Recommendation Report for Planning Permission for Works or Extension to a Dwelling

REF NO: R/242/21/HH

LOCATION: 9 Angmering Lane
East Preston
BN16 2TA

PROPOSAL: Erection of single storey rear extension and external alterations

A 02

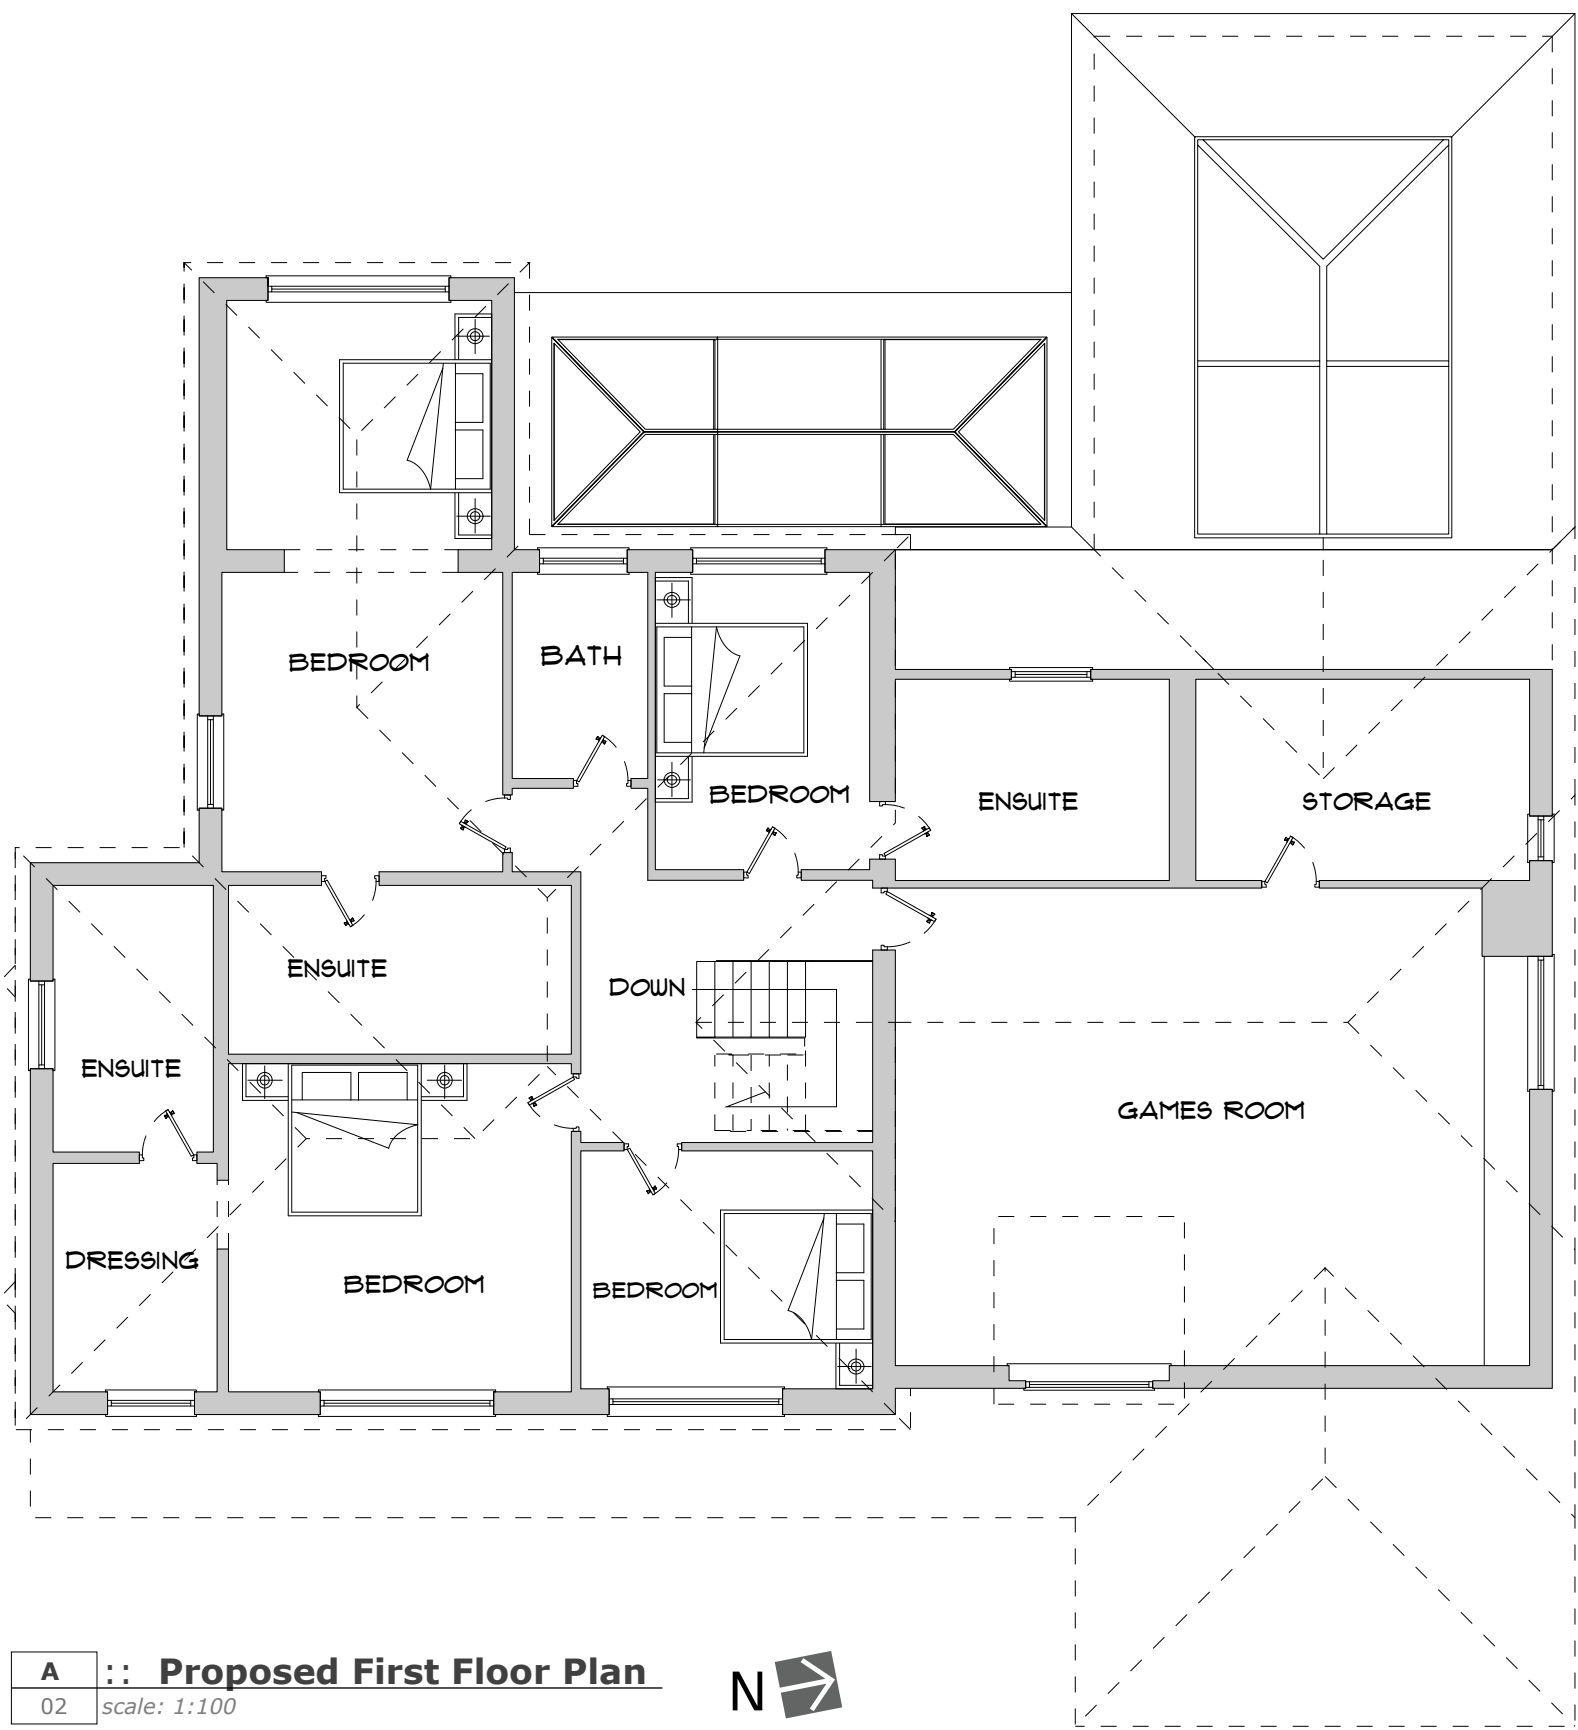
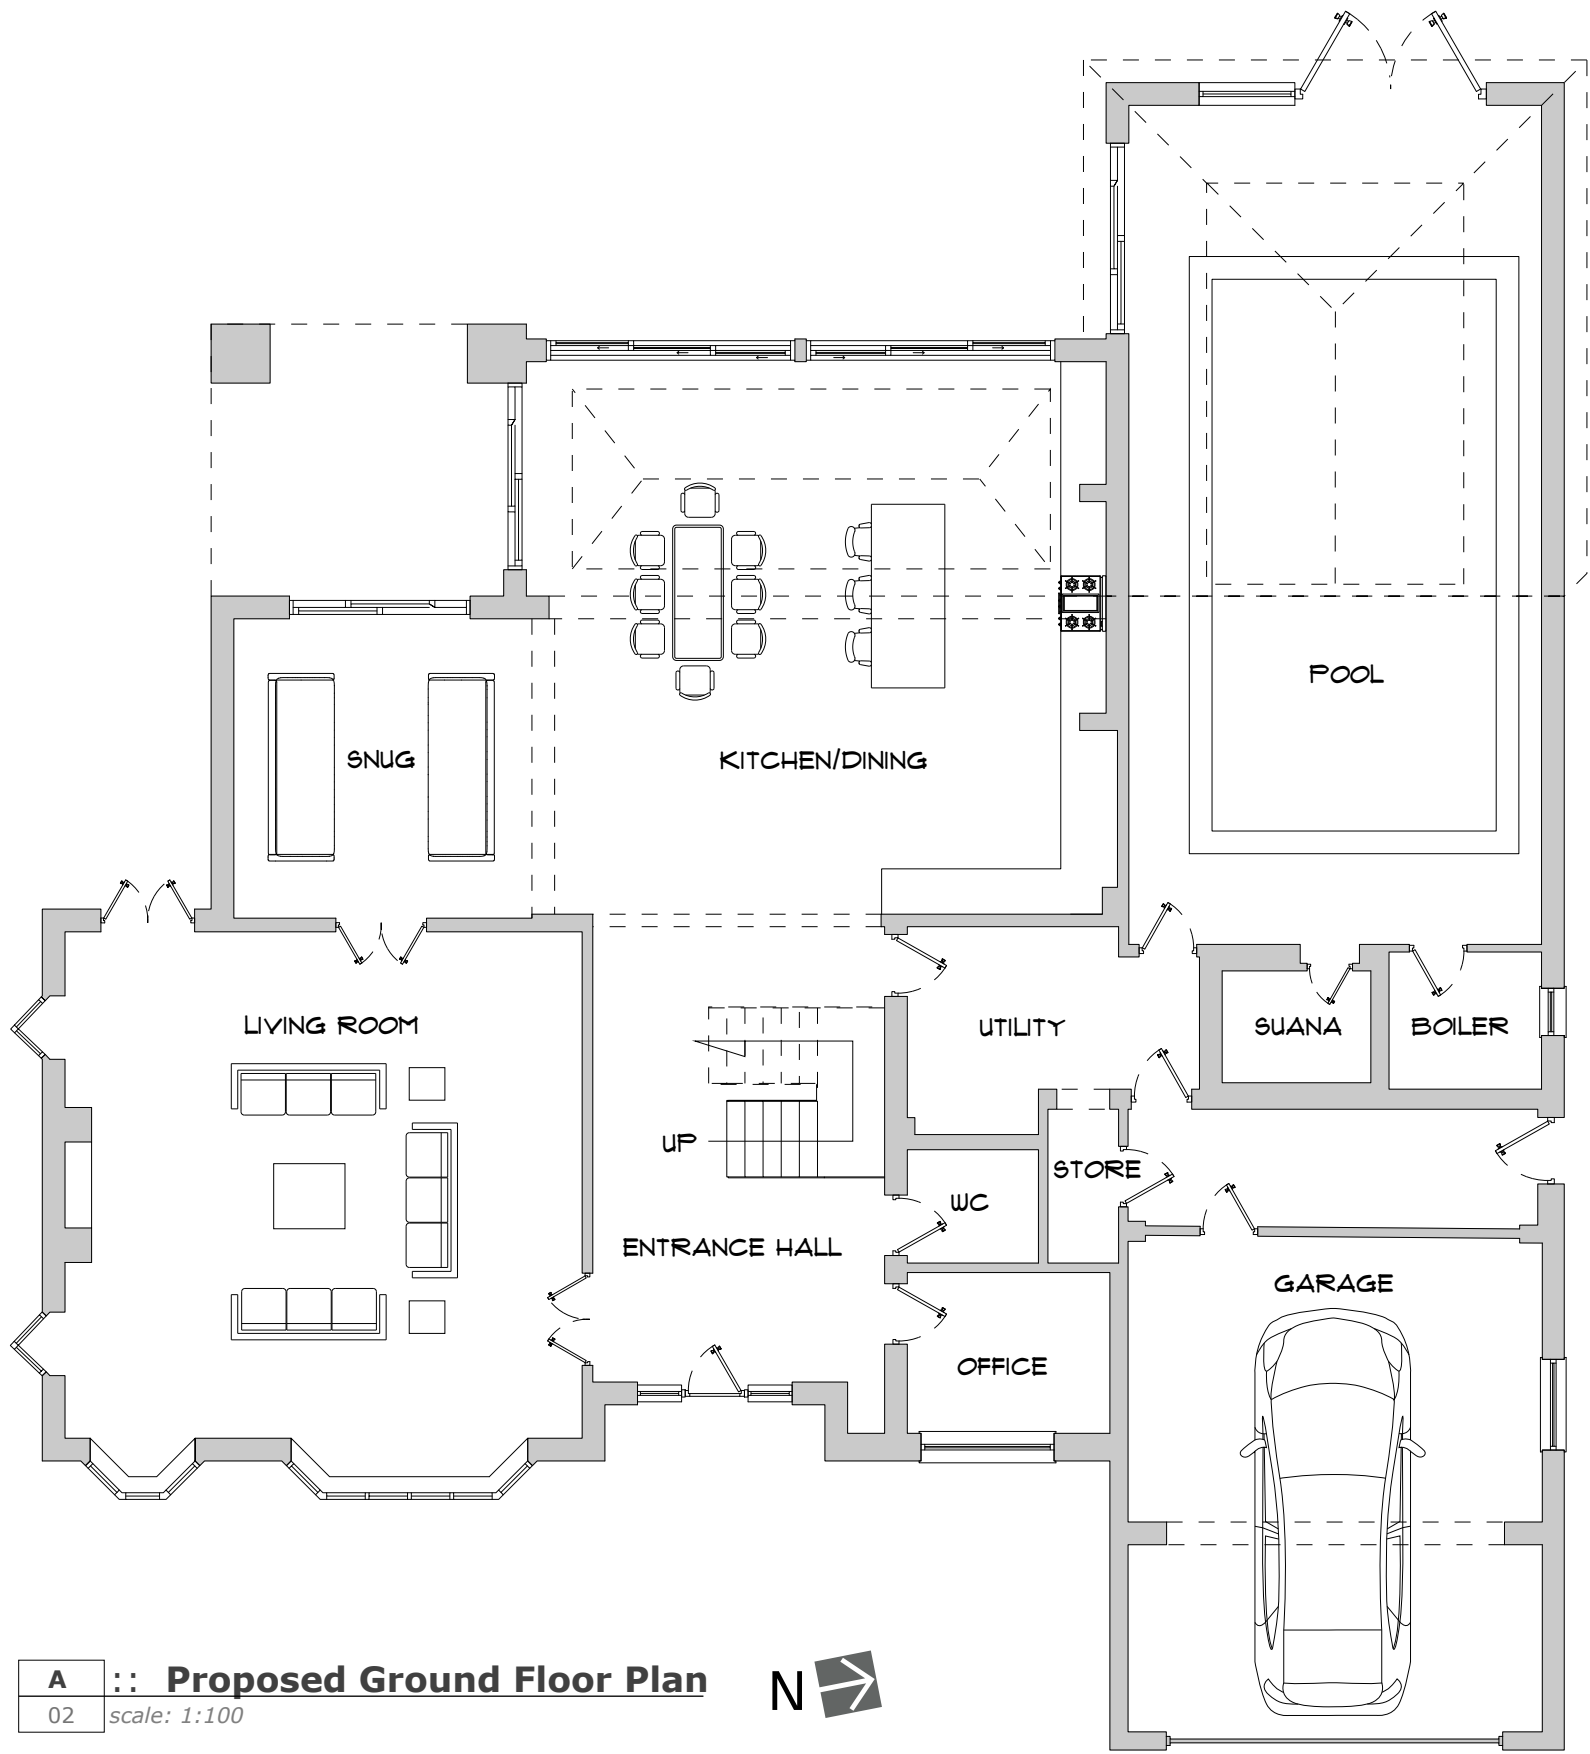
The proposed extension will have a flat roof design with a lantern light centrally located within the roof and being at single storey, is visually subservient to existing dwelling. The proposal will have a width of approximately 7.4mm and a depth of approximately 3.3m. The extension will not encroach on the side building lines created by the existing dwelling.

The extension is centrally located within the plot and a good length of rear garden will be retained above design guidance recommended levels.

The proposed fenestration will face towards the rear private amenity space of the host dwelling as such it will only achieve views already obtainable from the host dwelling.
